Recommendation Report for Planning Permission

REF NO: CM/53/19/PL

LOCATION: Kents Yard
Brookpit Lane
Climping
BN17 5QT

PROPOSAL: Change of use of barns to 3no dwellings - Resubmission of CM/25/19/PL

Proposed Site Plan 1:200@A3

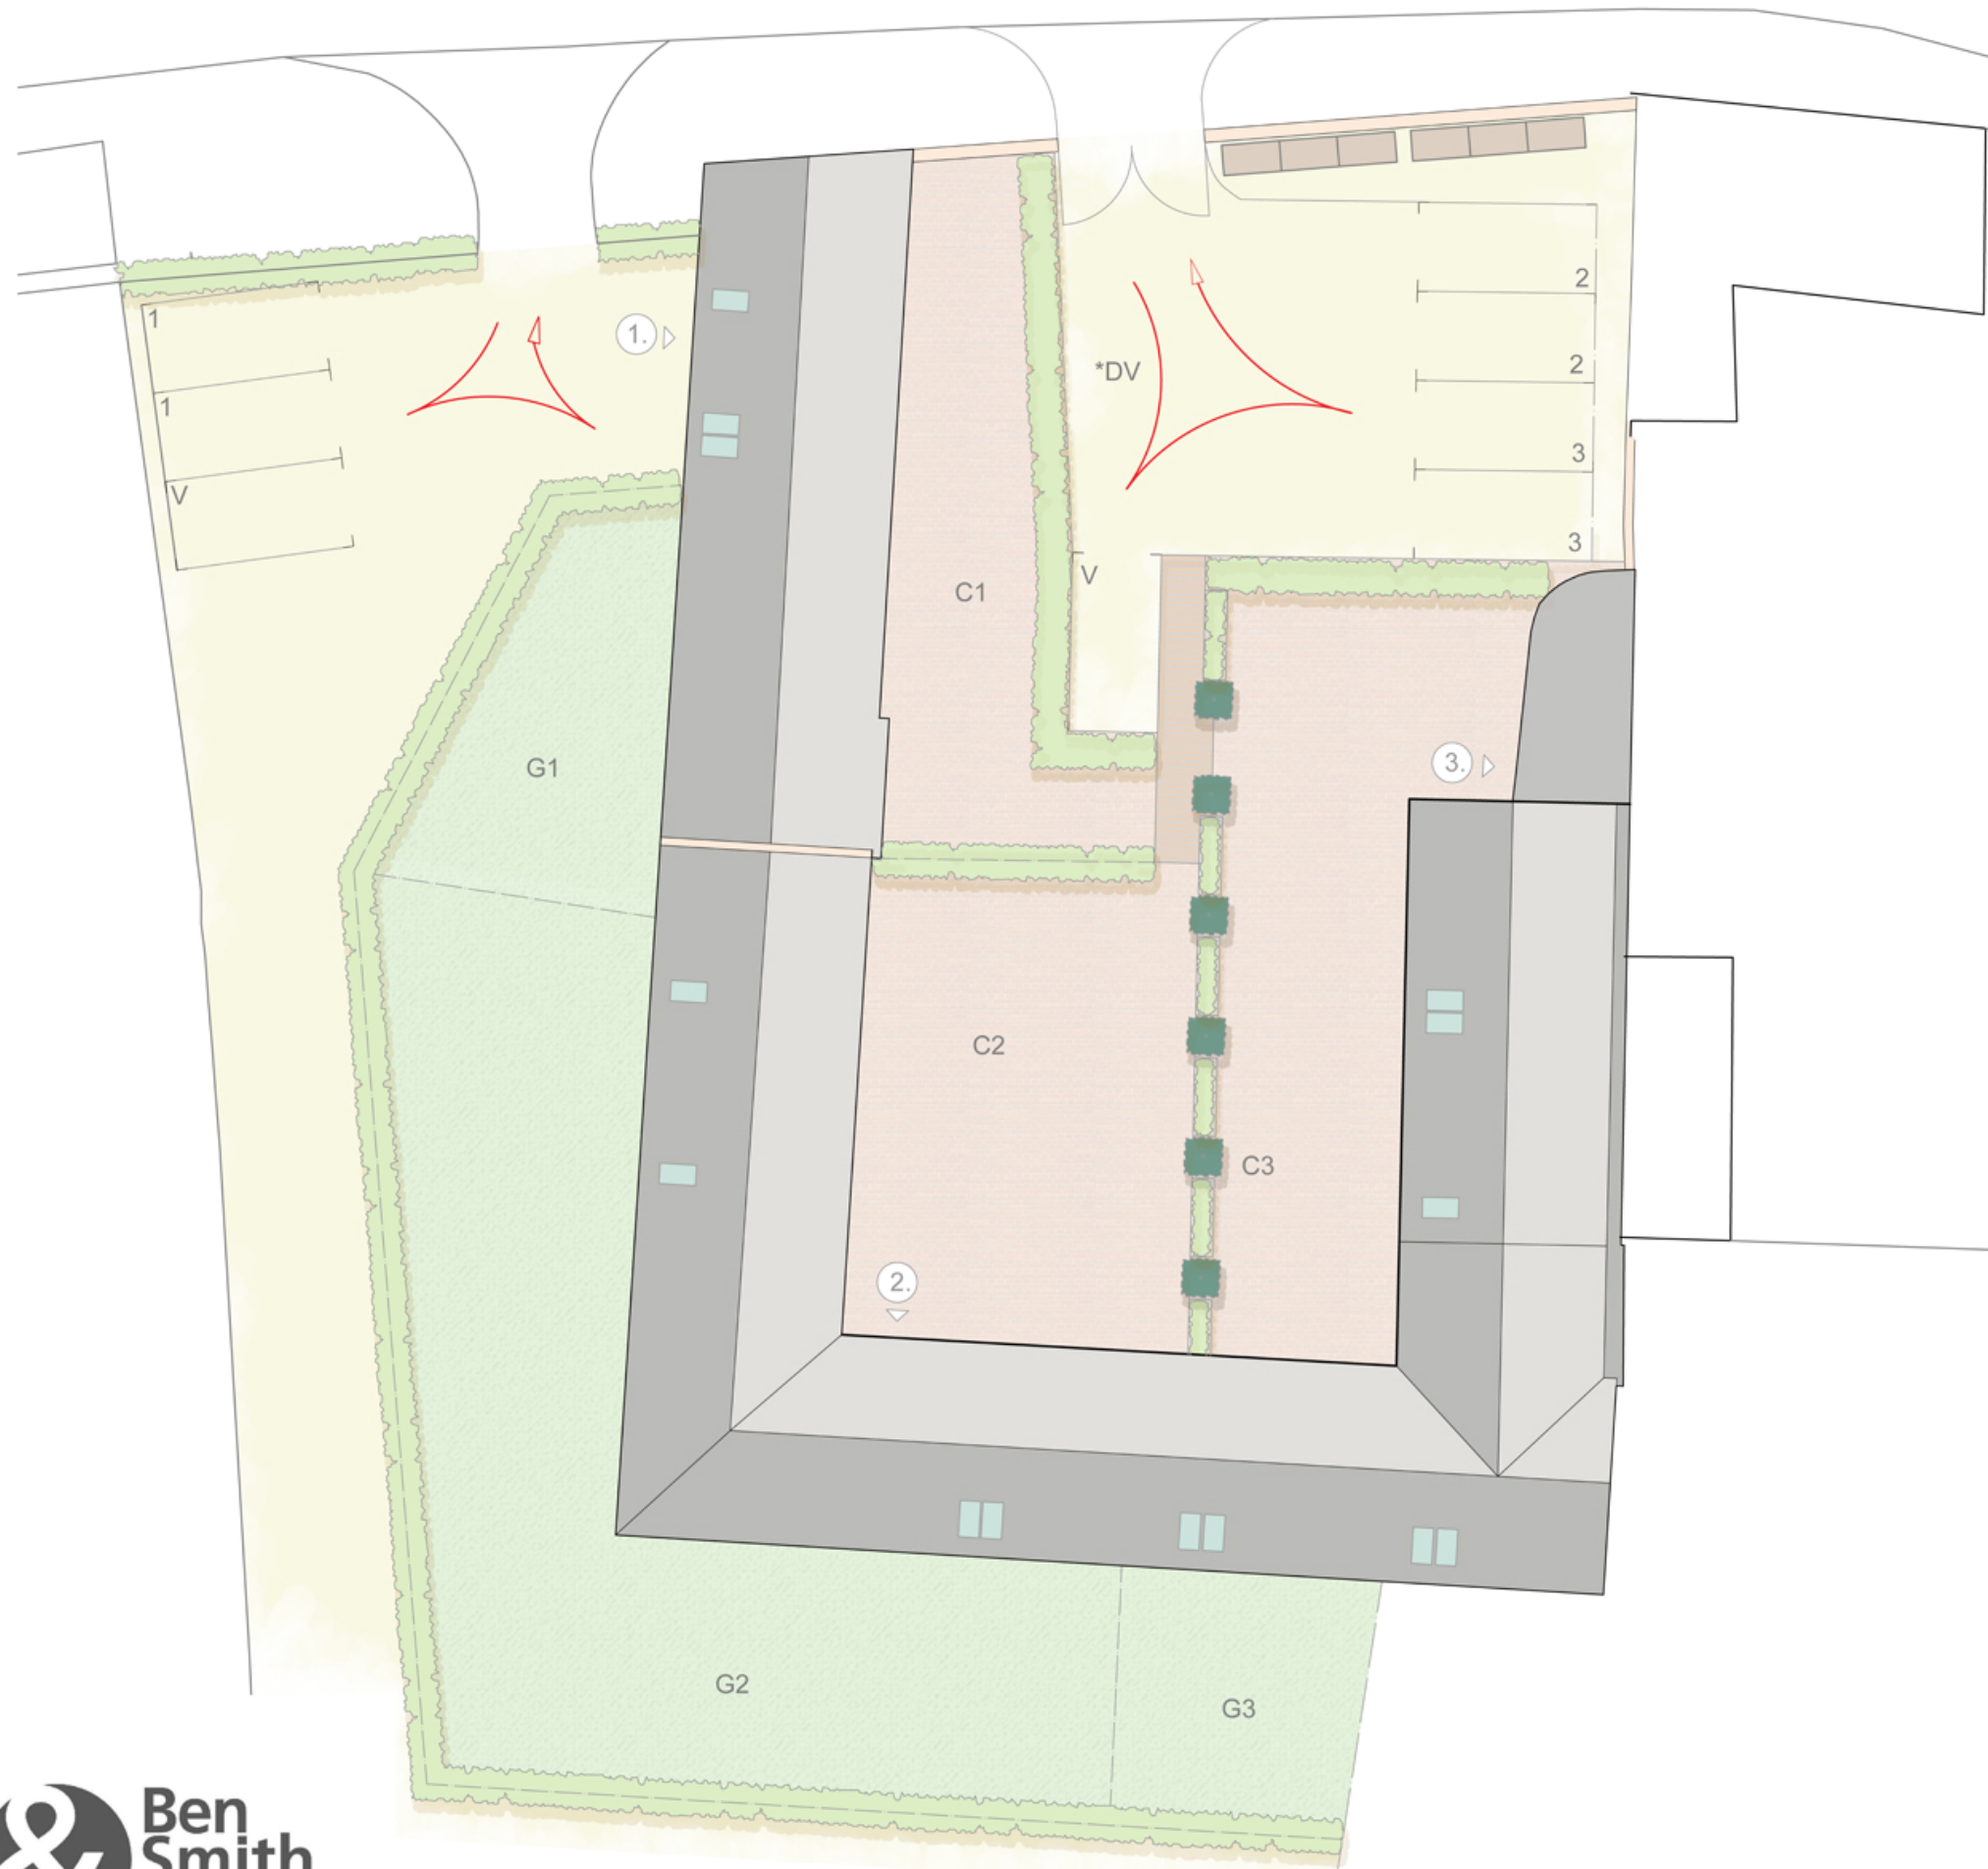
- It provides 2 visitor parking spaces.
- Delivery Vehicles are indicated to have turning space within the courtyard.
- A more detailed arrangement for the division of amenity space has been provided using low fencing and low level box hedging.

The proposed conversion is considered to result in a form of development that would be cramped and over intensive with inadequate amenity space resulting in an adverse impact on the character of the area. The proposed changes to the scheme would alter the scheme with the changes being providing more parking and adding low rise hedging and fencing which would not materially increase amenity space for the dwellings, simply cause a more cramped appearance to the dwellings and development as a whole. The development would be considered contrary to Policy D DM1 of the Arun Local Plan.

The proposed amenity space to the front of the dwellings is not considered to be usable given the low rise (1.2 metres) fencing and hedging that is proposed as the space would be overlooked by neighbours as they entered and exited their properties. This would leave the amenity space to the rear which for units 1 and 3 which would remain inadequate.

The proposal would adversely affect the setting of the adjacent Listed building, Kent's Farmhouse. The subdivision of the internal courtyard would be contrary to the concept of the space having been used as an agricultural courtyard space which would have a negative impact on the established character of the building and its context. The Council's Conservation officer objects to the proposal and considers it would cause harm to the significance of the setting of the heritage asset.
